P001042 JEP Kariong Sand DPIE RFI response Feb2021

Response of comments from DPIE review for Kariong sands (SSD-8660)

PROJECT: PROPOSED KARIONG SAND & SOIL SUPPLIES FACILITY - SSD8660
GENERAL ARRANGEMENT PLAN

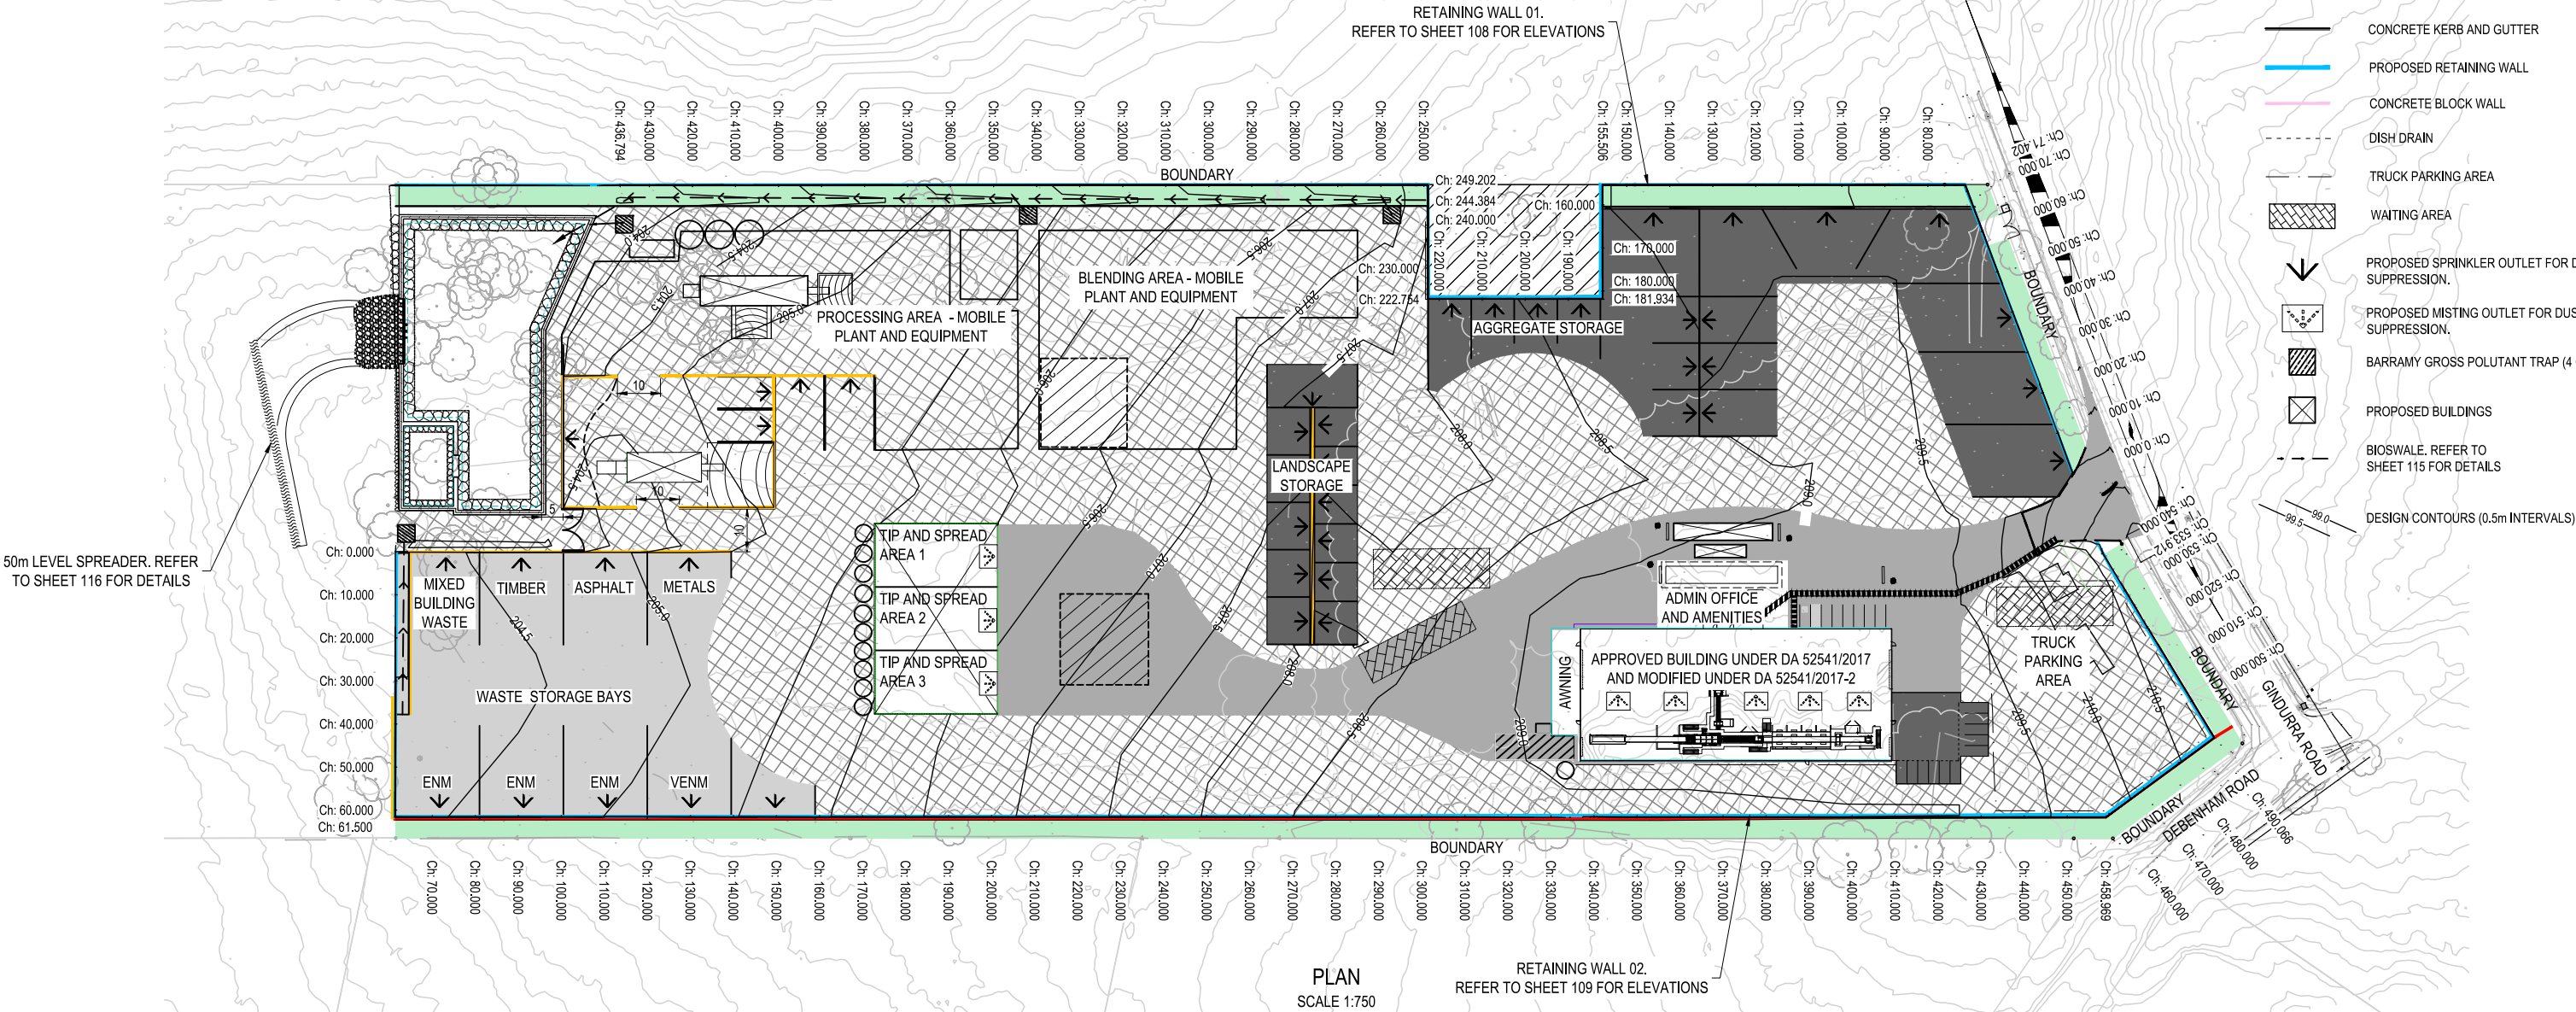
- The central median on the driveway can have a gap provided in the median to allow for pedestrian movements across this driveway. The median is raised to reinforce that trucks exiting the must turn left out of the site only. This median will be designed in accordance with Austroads Standards and Council guidelines as applicable and cater for a pedestrian crossing this driveway in 2 stages.
